**Town & Country Planning Act 1990 (as amended)**  
**Town and Country Planning (Development Management Procedure) (England) Order 2015**

**Application for Planning Permission**

**Development:** Retention perimeter post & rail fence to the back edge of road side verge with gated access from Chichester Road & North Bersted Street. This application may affect the setting of a listed building & the site is in CIL Zone 4 (Zero Rated) as other development.

**Location:** Car Park Adjacent To The Royal Oak Public House Chichester Road Bognor Regis PO21 5JF

Title
Block and Location Plans

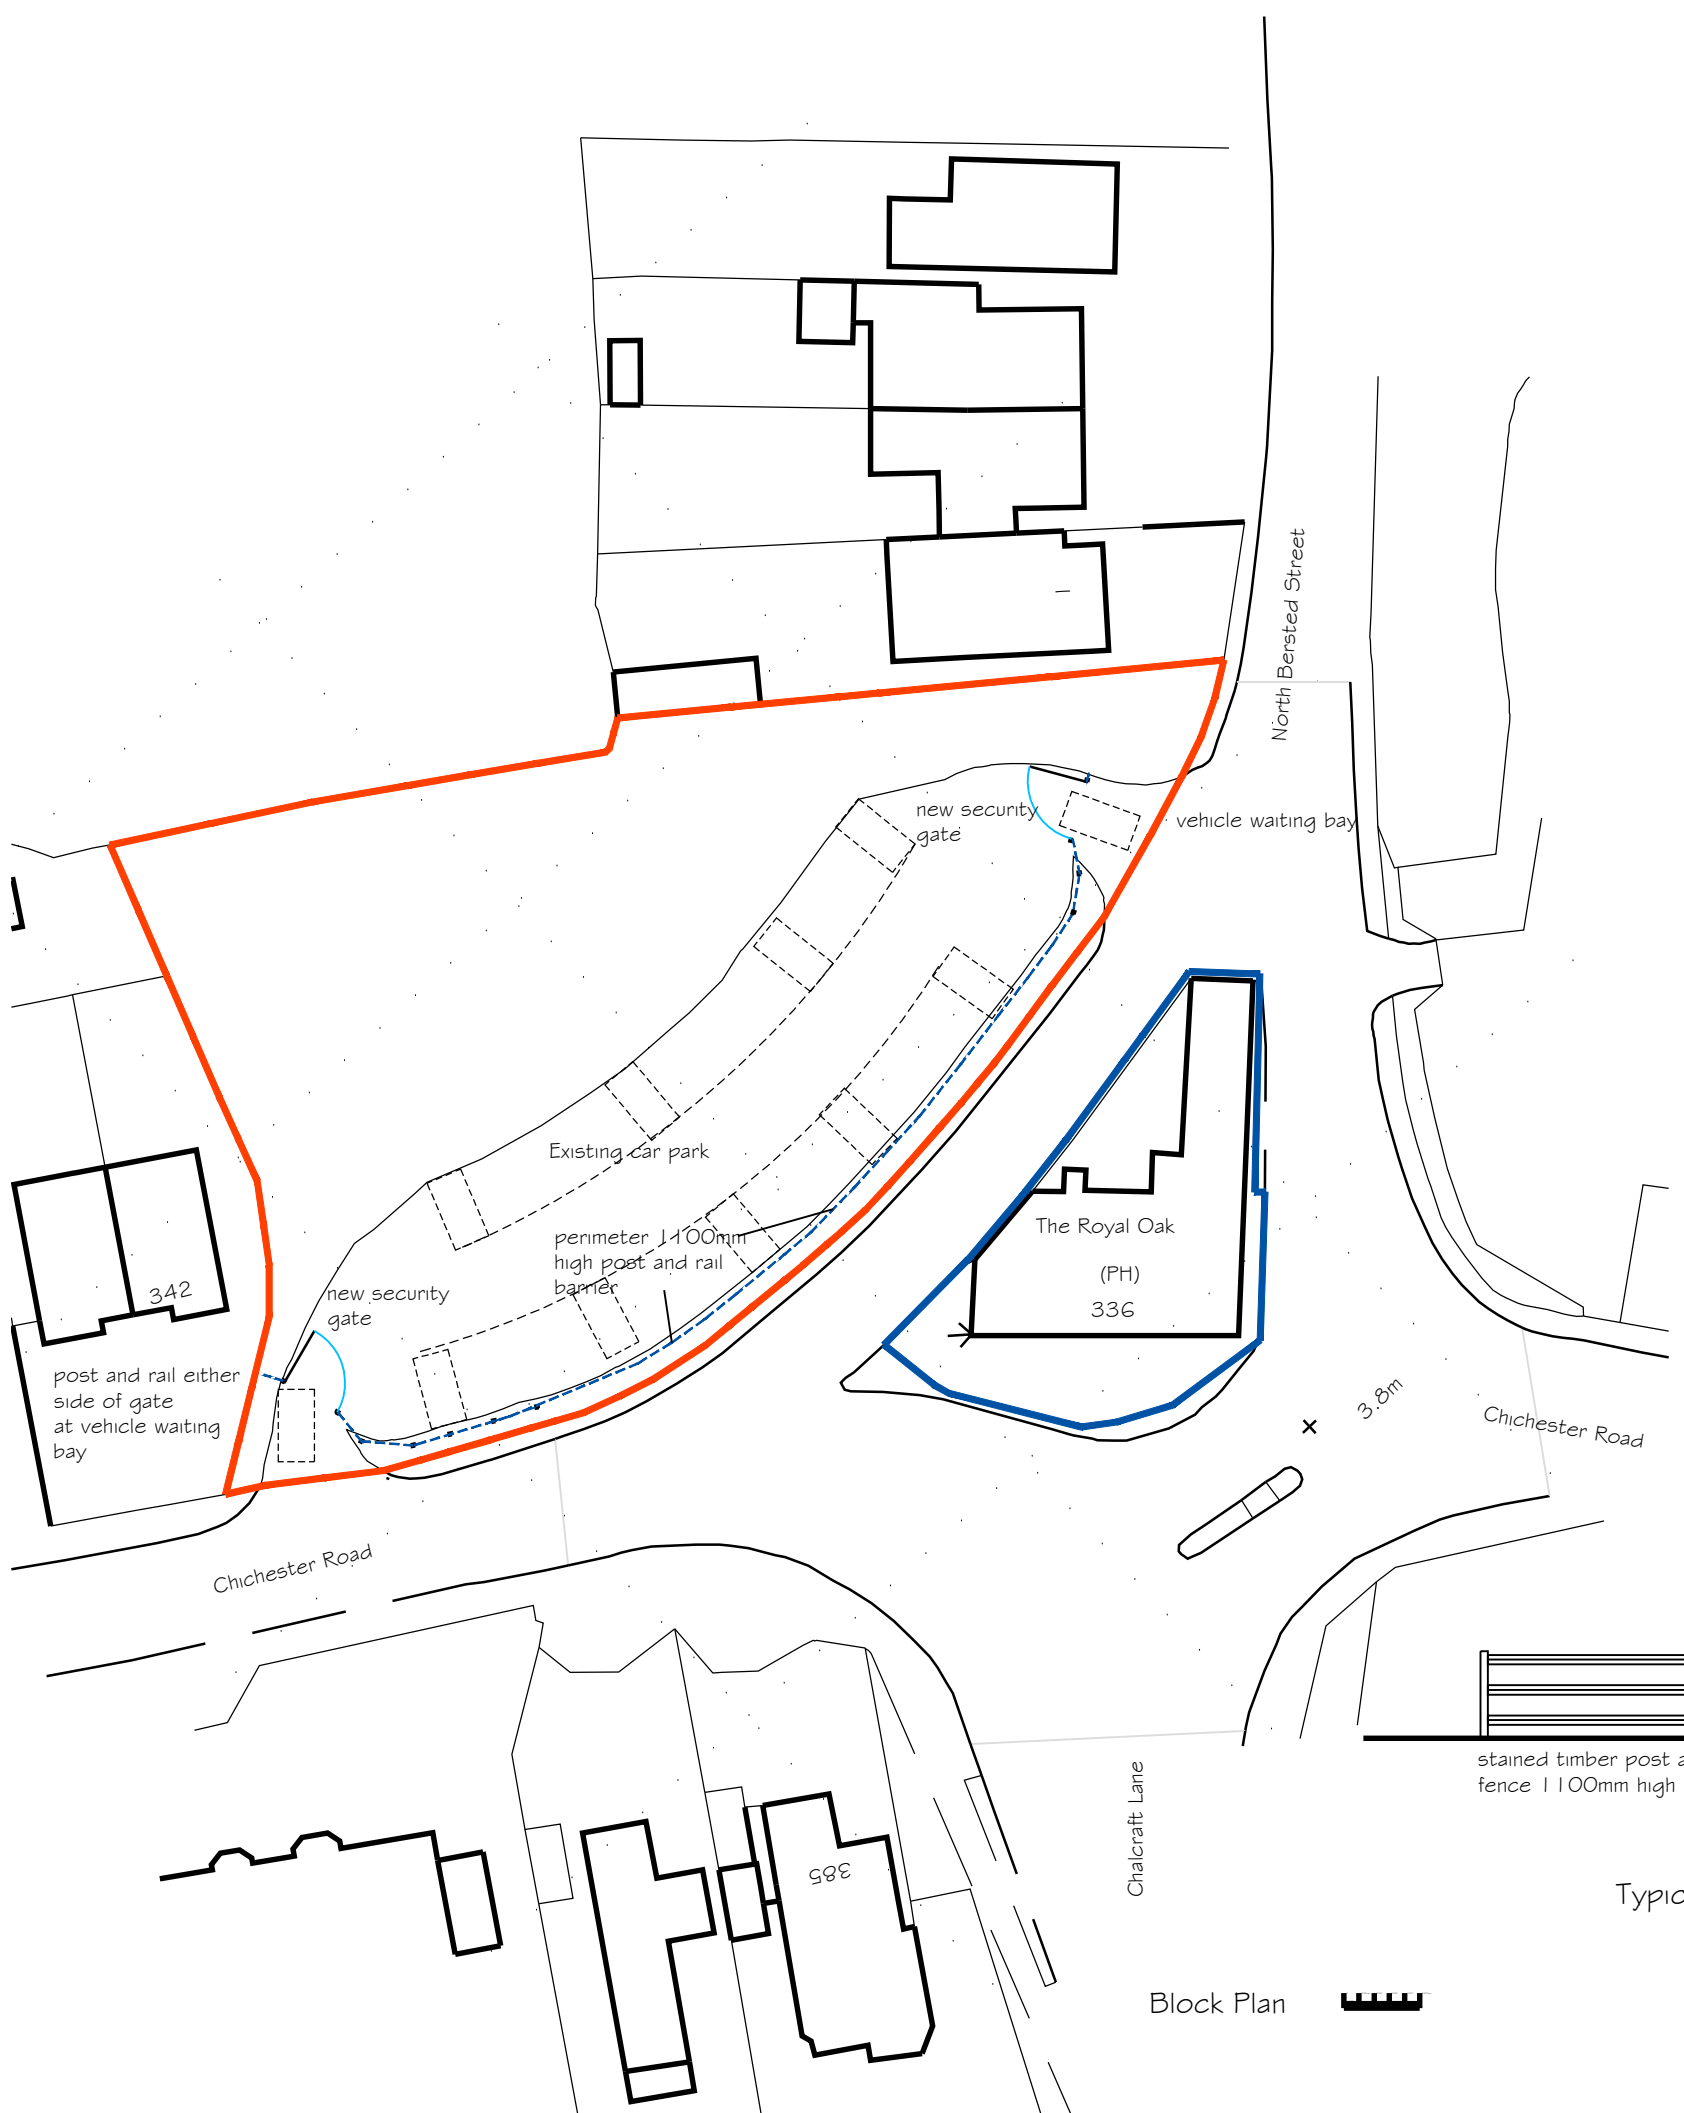
The application form indicates a new access from the highway. On the block plan, please clearly indicate the new access and provide visibility splays.
